**Consultation Response from KC,  
Highways Development Management****2023/93797 Former Liberal Club, 14, New Road, Kirkheaton, Huddersfield, HD5 0HP****Erection of extensions and alterations to former club to form 6 apartments****Date Responded: 04/04/2024****Responding Officer: Ryan Kinder****Responding Ref:K11-15SW/26**

2023/93797 Former Liberal Club, New Road, Kirkheaton.

Planning application for Erection of extensions and alterations to former club to form 6 apartments.

Ground Floor Plan - 1:100

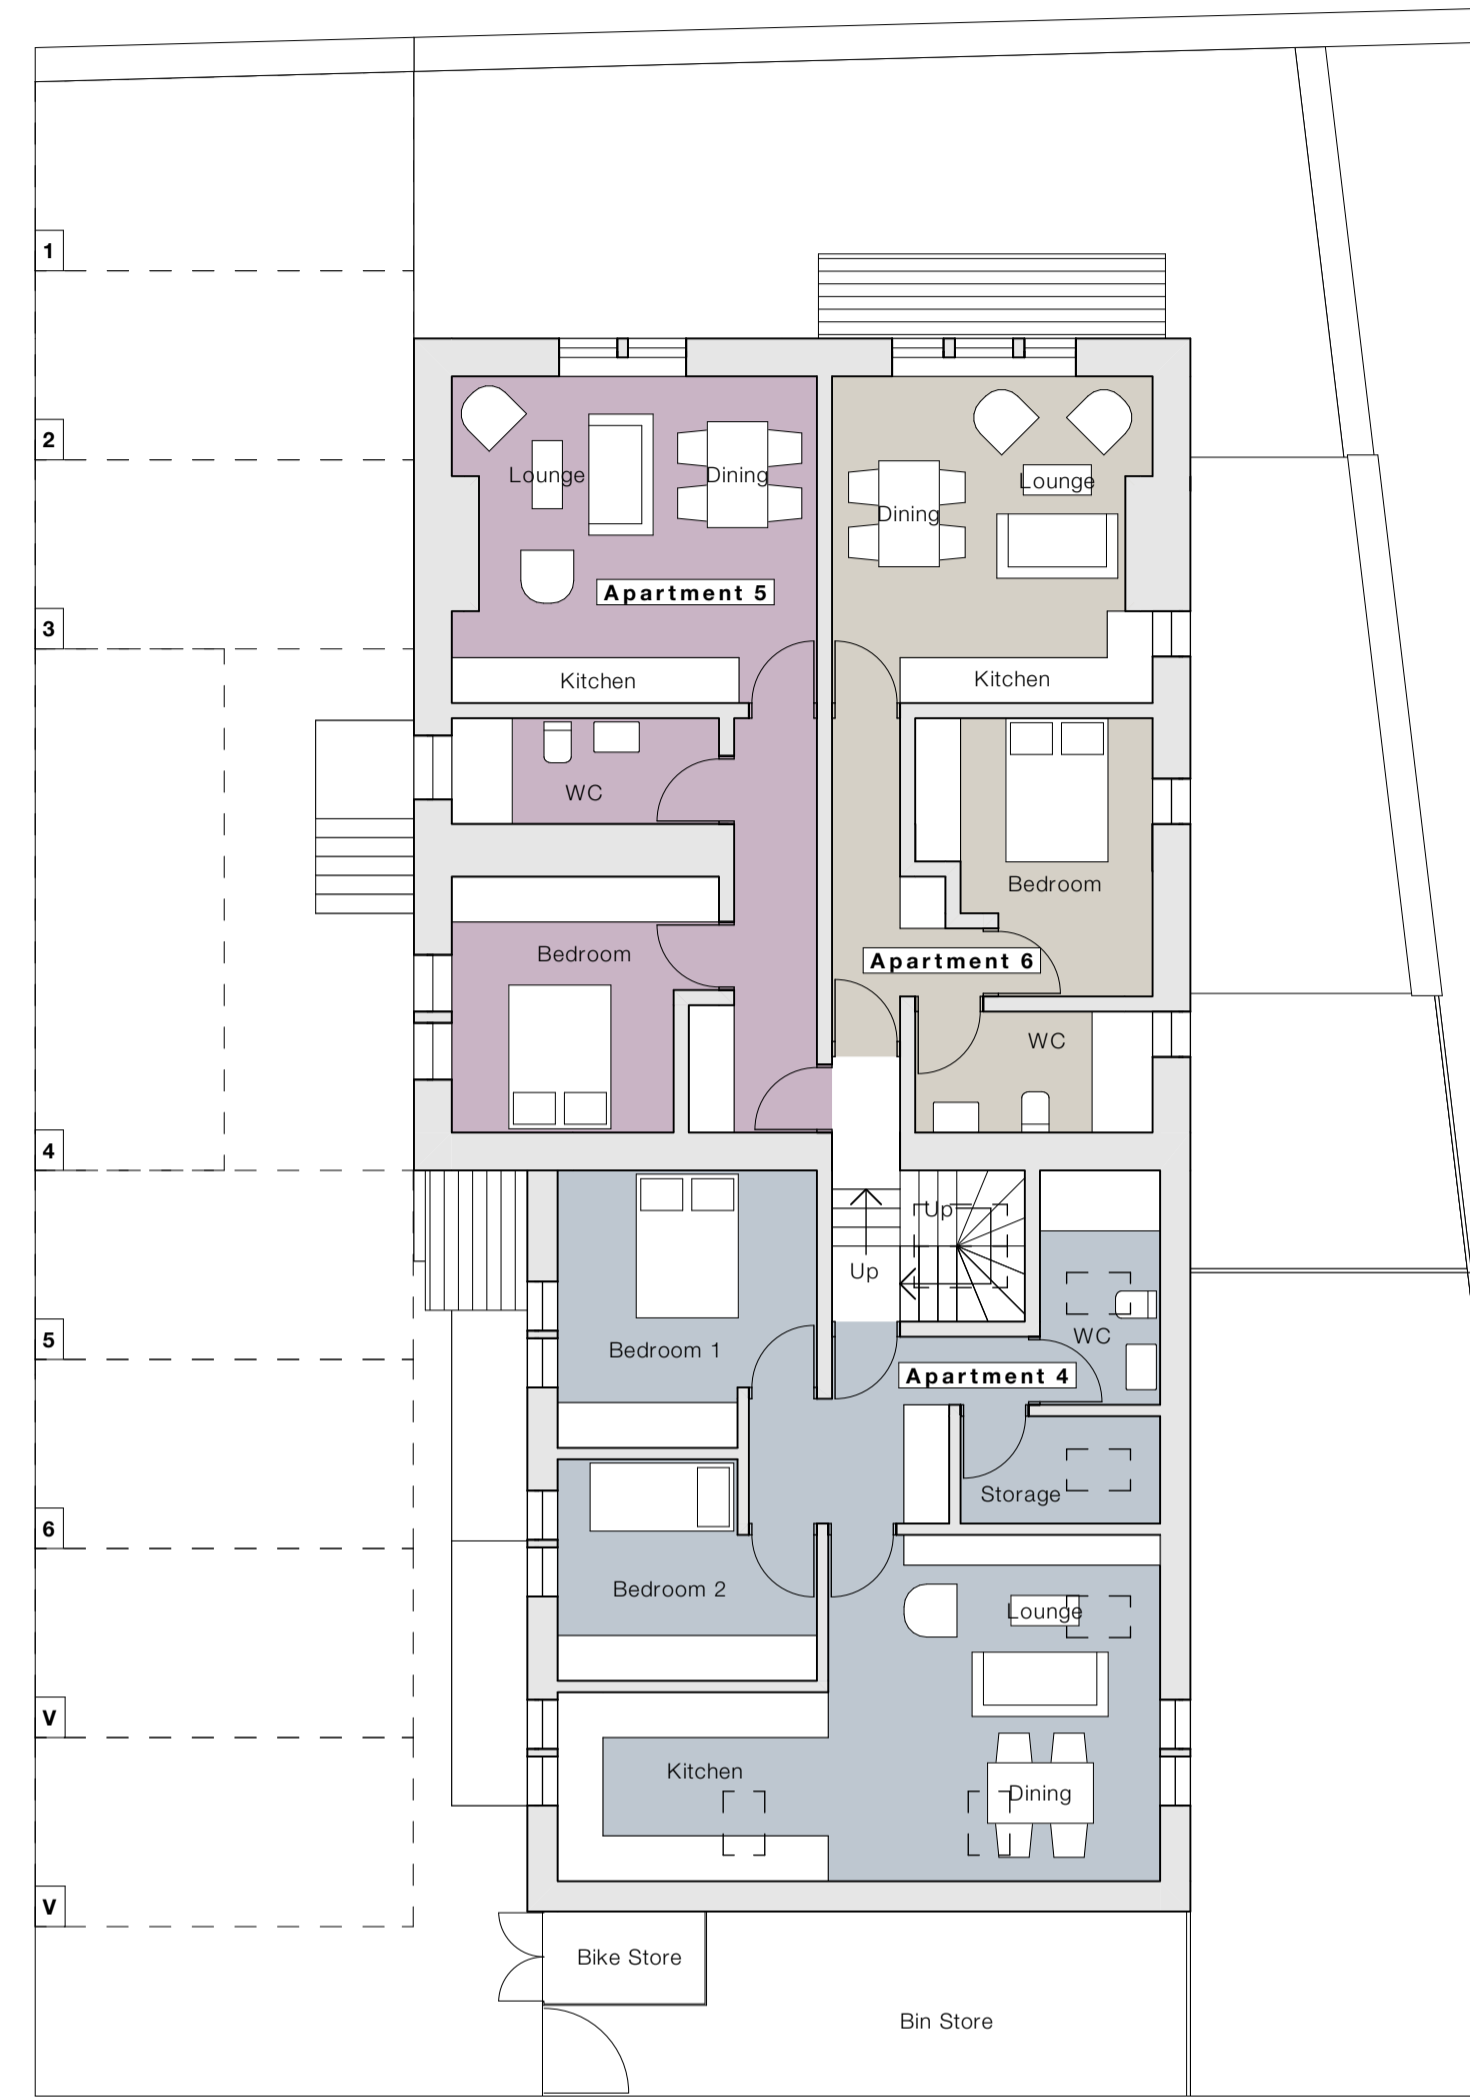
The site takes access via St Johns Avenue with parking provision for 6 vehicles plus an additional 2 visitor spaces, this is considered sufficient for a development of this size.

Further to a pre planning application on this site it was advised on the requirements for a suitable sized refuse storage area. The Councils Waste strategy team have advised again that the current bin store is not large enough to accommodate the required sized bins. Guidance indicates the floor space for 1 no 1100ltrs wheeliebin is 1575mmx1190mm with space required to manoeuvre the bins within the store. The proposed store on the plan shows overall dimensions of approximately 2.2m x 1.5m with a gate width of 1.2m. As such it suggested a suitable condition to ensure this issue is dealt with be recommended.

“Before development commences, details of suitable storage, bin presentation points and access for collection of wastes from the dwellings hereby approved shall be submitted to and approved in writing by the Local Planning Authority. The approved details shall be provided before first occupation and shall be so retained thereafter.”
